Application no: H08-0202-10

Description: Extension to rear of dwelling

Location: Westview
Windmill Lane
Gosberton Risegate
Spalding Lincs
PE11 4ES
PE11 4ES

Amendment: Removal of garage (dwg. nos. JWM/WV/003B, /004B,
/005A, /006, /007B, /008B and /010)

Project JWM/WV/003B
Date 01/03/10
Scale 1:100
Proposed ELEVATION

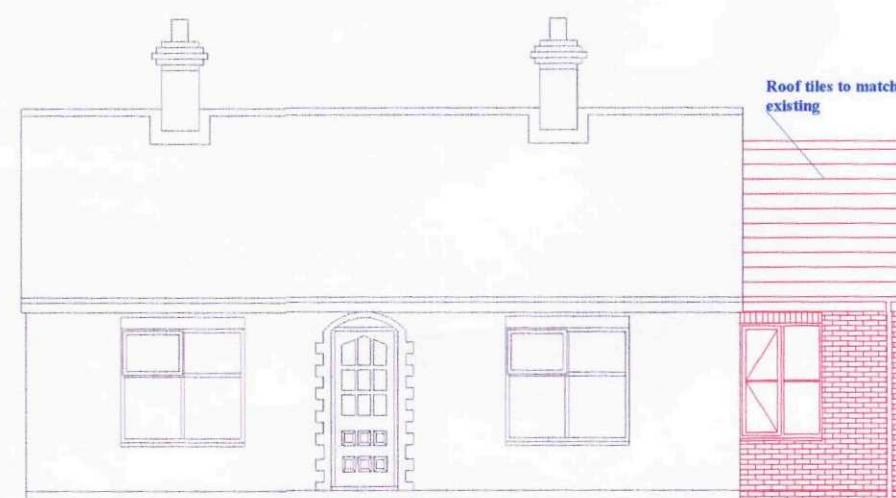
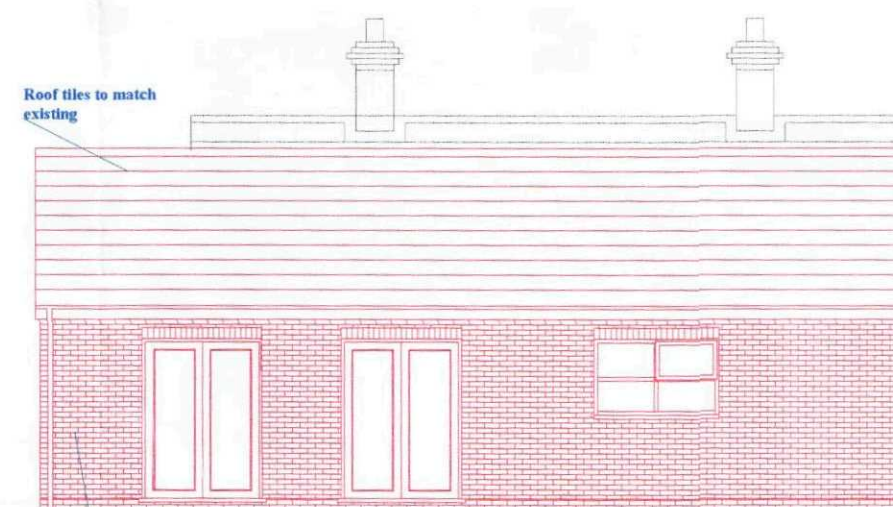
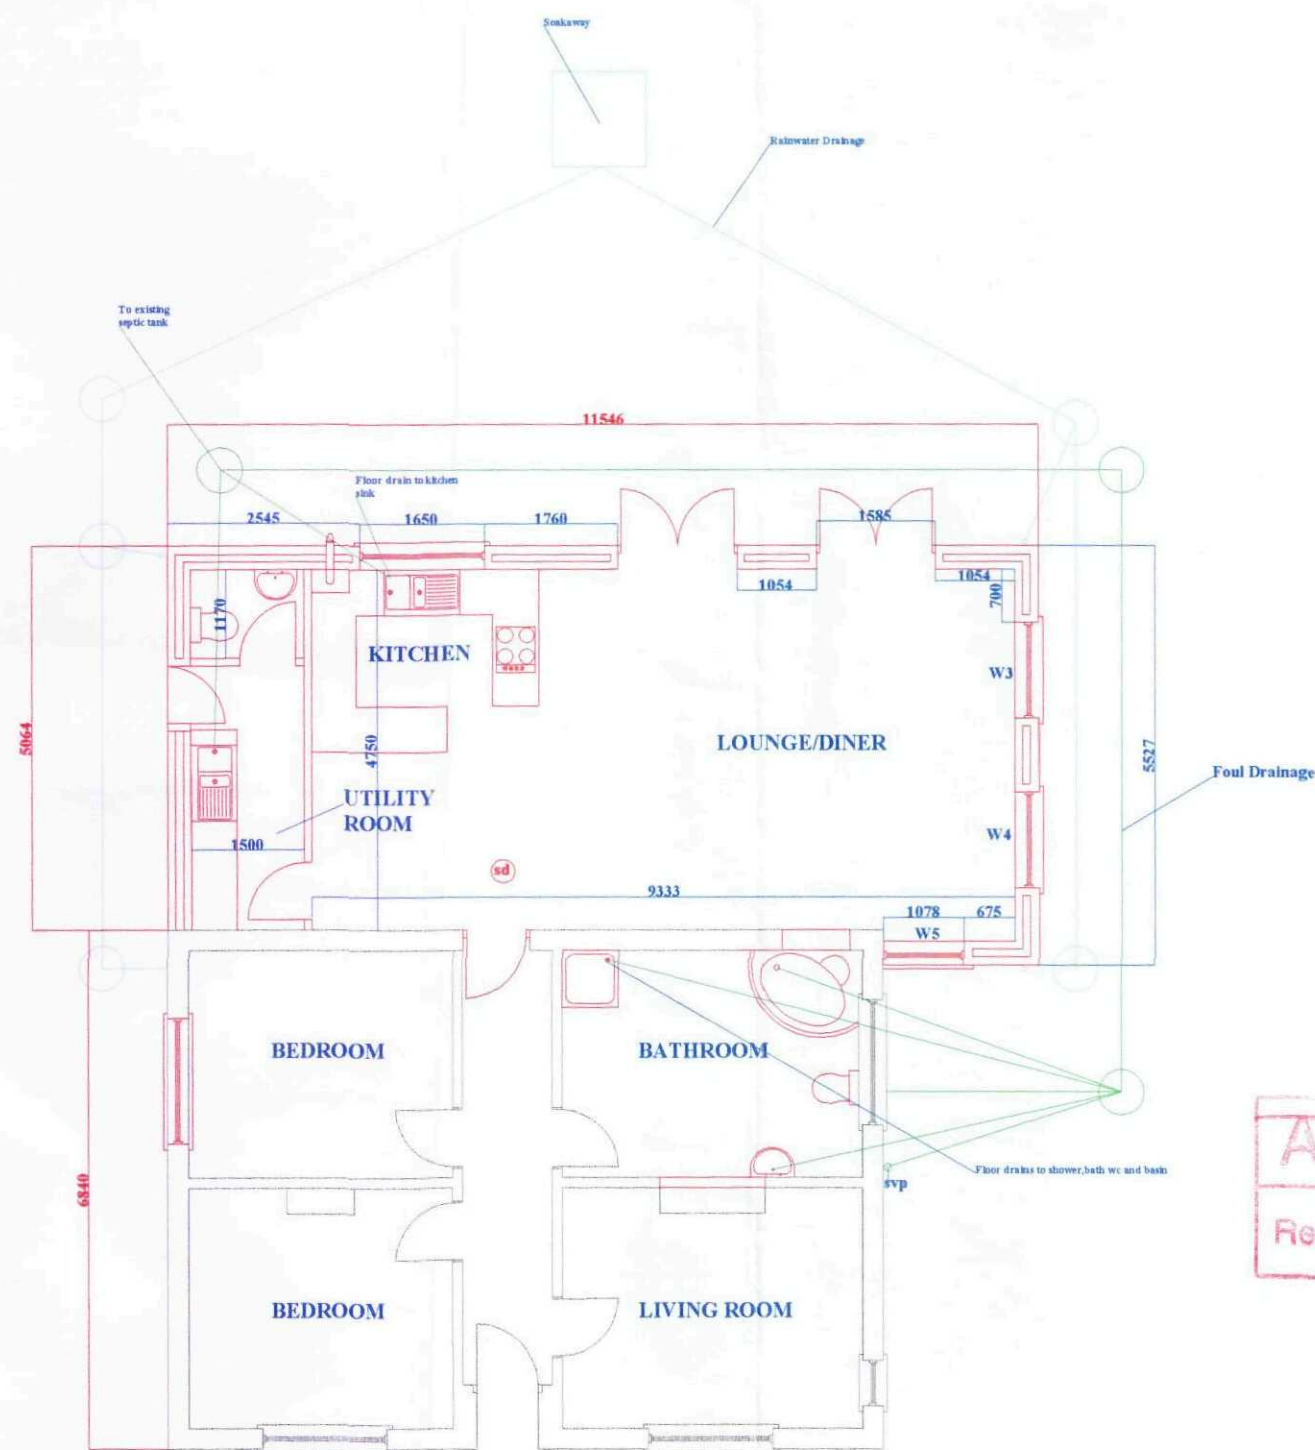
Following our meeting on site I have discussed the proposed changes with my clients. They have now agreed to remove the garage from the application. Accordingly I enclose two copies of the revised drawings.
